Recommendation: Refuse

Applicant: Mr Jon Naisbit

Proposal: Two storey side extension and single storey rear extension.

Proposed Floor Plans

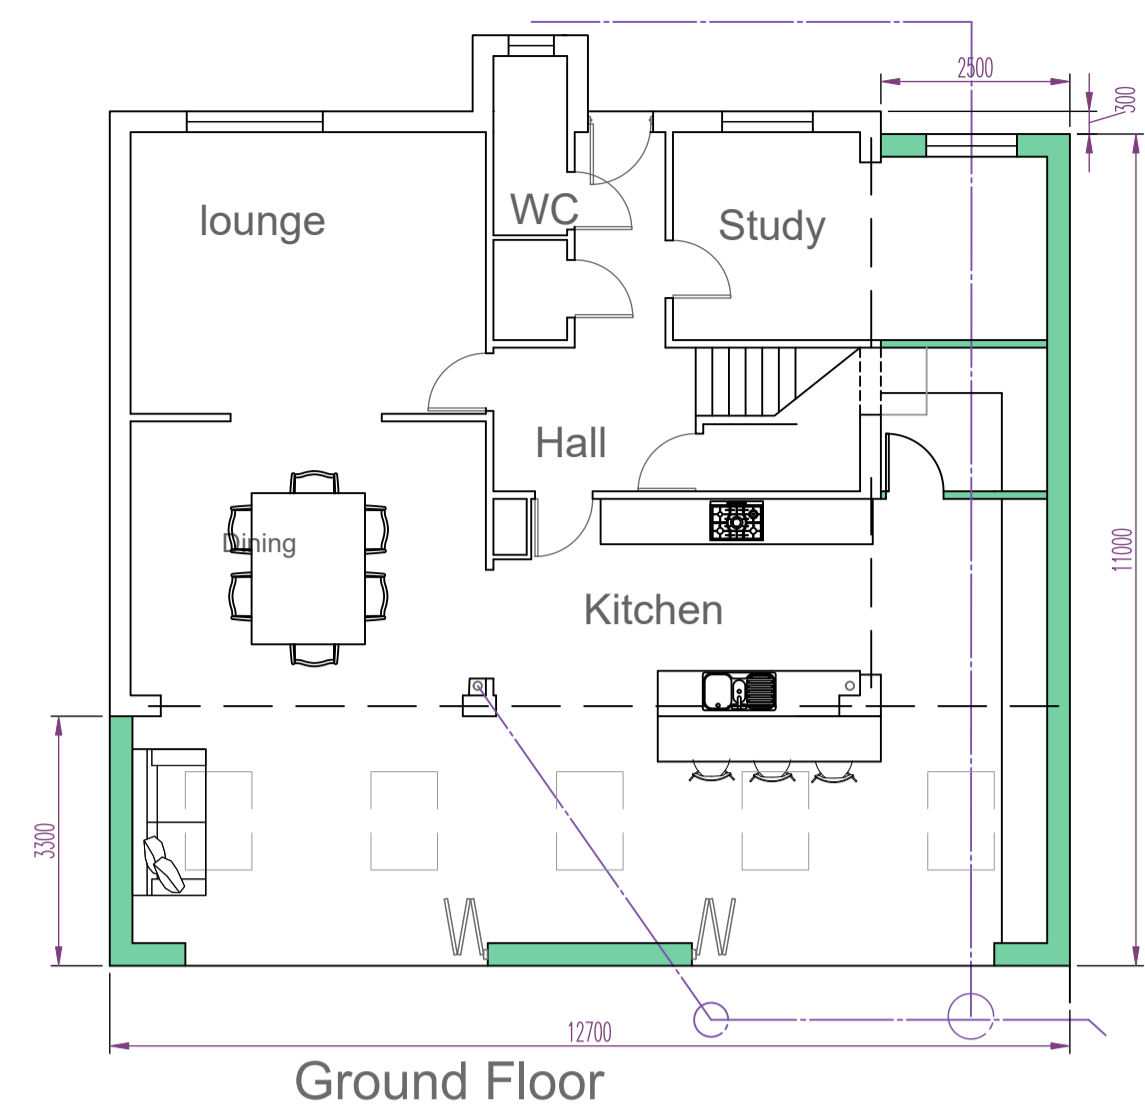
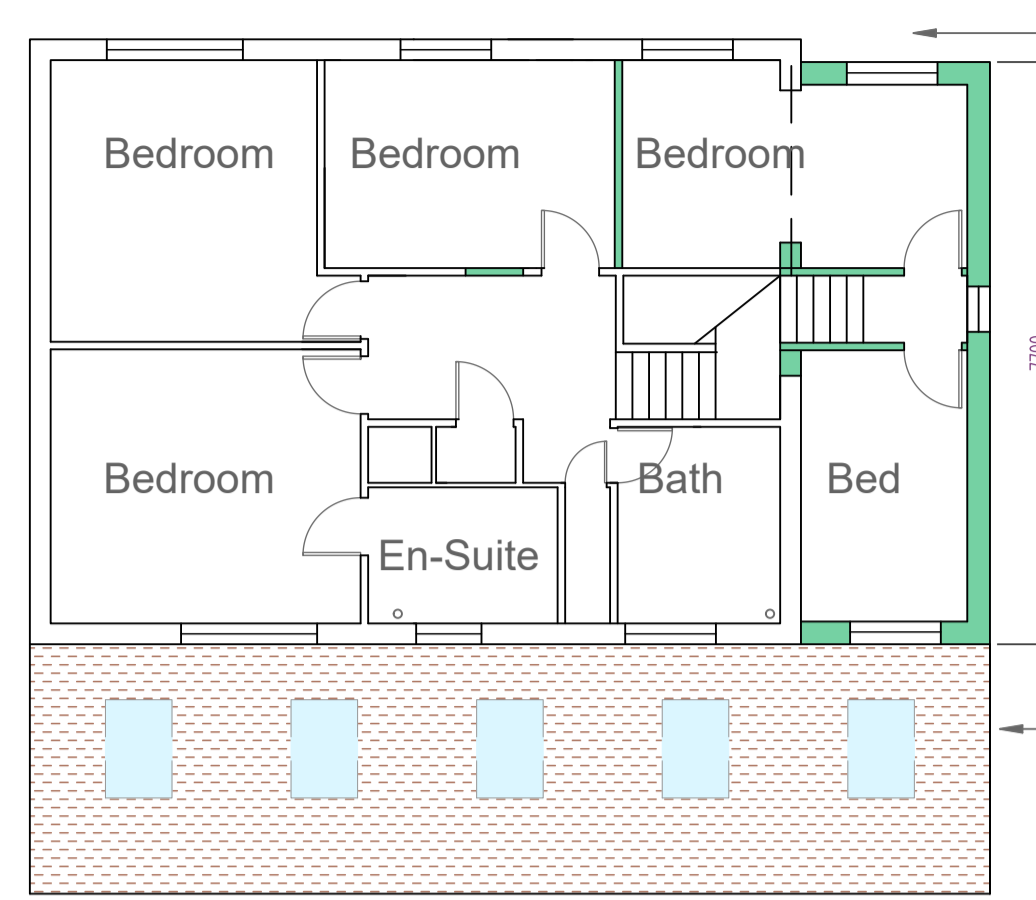
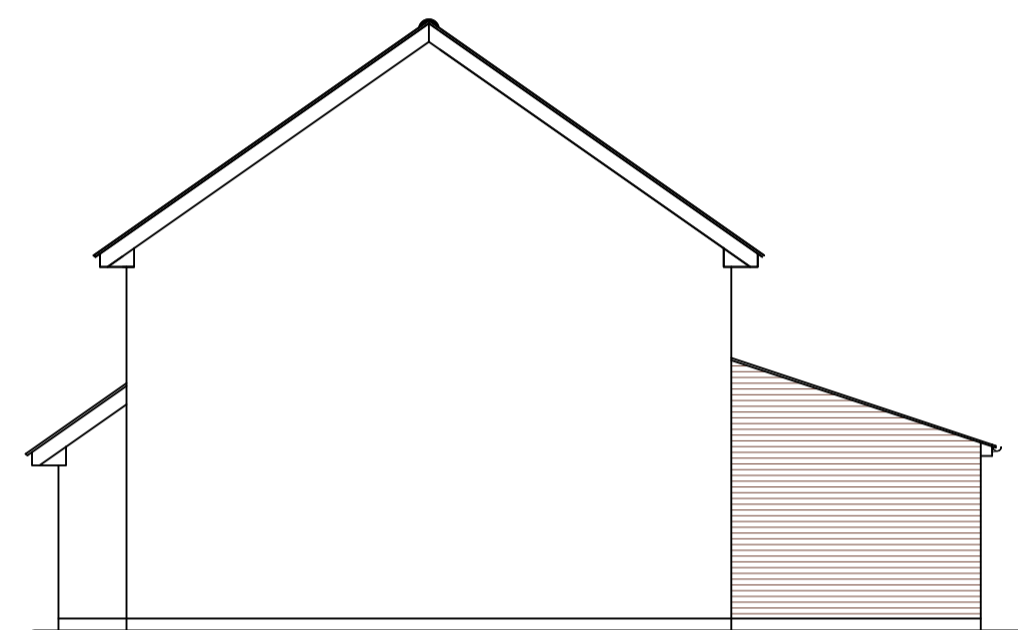
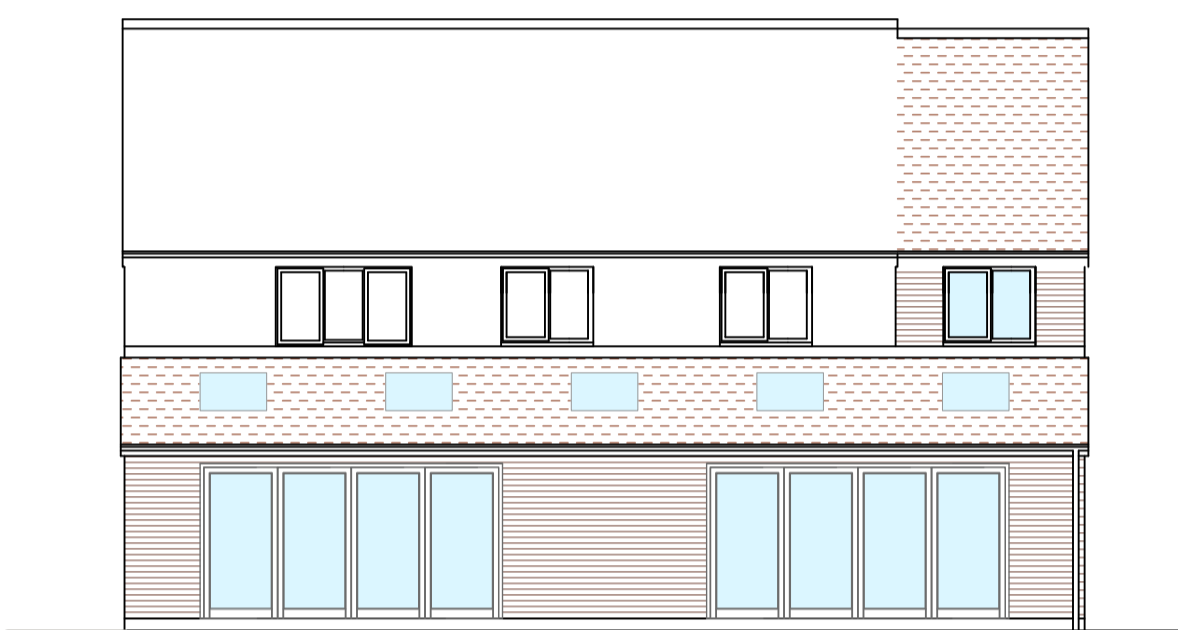
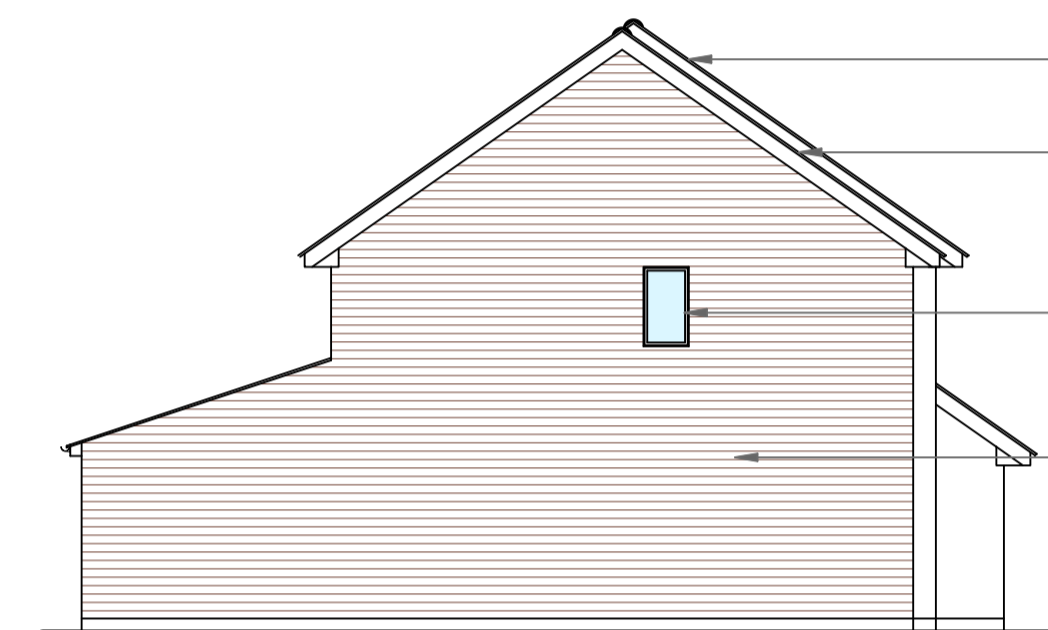
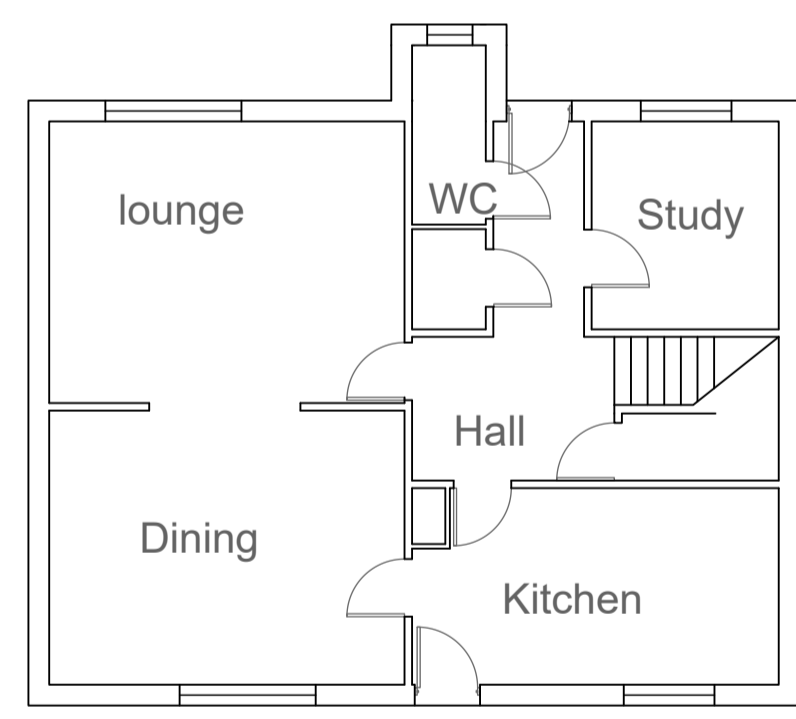
The proposed two storey side extension would be set in from the front elevation by 0.3 metres and its roof would be set c. 0.12 metres below the ridge of the host

dwelling, thus providing a minimal degree of subservience, which while sub optimal is considered sufficient to ensure that the proposed development would read as a subordinate extension to the host dwelling. The proposal would extend beyond the existing building line, would sit against the boundary of the plot, and would have an overbearing impact on the adjacent piece of soft planted public amenity land and therefore it is considered that the size scale and positioning of the proposed two storey side extension would have a sufficiently detrimental impact on the character and appearance of the host dwelling and the wider area to justify the refusal of planning permission. Furthermore, it is noted that a first floor soldier course in contrasting brick is a prominent feature of the host dwelling and characteristic of dwellings in the wider area and this has not been shown on the existing or proposed plans and would need to be carried across from the host dwelling to the extension in order for any such proposal to be acceptable in visual amenity terms. The proposed single storey rear extension would have a modest depth and height and would integrate well with the host dwelling and would not have an adverse impact on the character and appearance of the host dwelling, however, due to its location against the boundary of the plot the proposed single storey rear extension would have a severe detrimental impact on the trees located on the adjacent amenity land and would therefore have a detrimental impact on the wider area. Overall, the proposed development is not considered acceptable in design terms. and therefore, objections are raised with regard to the design elements of Policies: ESD15, C28 and C30.

The proposed development would have a positive impact on the amenity of the current and any future occupants of the host dwelling. However, due to its size scale and position within the plot it is considered that the proposed single storey rear extension would have an adverse impact on the adjacent amenity land and on the amenity of neighbouring properties. While the proposed two storey side extension would not extend beyond the rear elevation of the host dwelling, due to its position to the south of the dwelling and its ridge height it is considered that the proposed extension would have a modest adverse impact on the amenity of the neighbouring dwelling to the rear by way of loss of light and outlook, which in combination with the adverse impact of the proposal as a whole on the semi-mature trees along the southern boundary of the plot, would result in an overall adverse impact that is considered sufficiently severe to justify the refusal of planning permission on this occasion. Having regard to the above the proposed development is not considered acceptable in amenity terms and therefore, objections are raised with regard to the amenity elements of Policies: ESD15, C28 and C30.

1. Due to its size, scale, positioning and design the proposed development would fail to respect the established building line and would fail to integrate with its host dwelling such that it would appear as an unsympathetic addition to the host dwelling that would have a detrimental impact on the character and appearance of the host dwelling and the wider area contrary to the provisions of Policy ESD15 the Cherwell Local Plan 2011-2031 Part 1, saved Policies C28 and C30 of the Cherwell Local Plan 1996 and Government guidance contained within the National Planning Policy Framework.

2. Due to its scale and position within the plot the proposed development would have a significant adverse impact on the adjacent amenity land and the trees contained therein, and would have an adverse impact on the amenity of neighbouring properties by way of loss of light and outlook area contrary to the provisions of Policy ESD15 the Cherwell Local Plan 2011-2031 Part 1, saved Policies C28 and C30 of the Cherwell Local Plan 1996 and Government guidance contained within the National Planning Policy Framework.
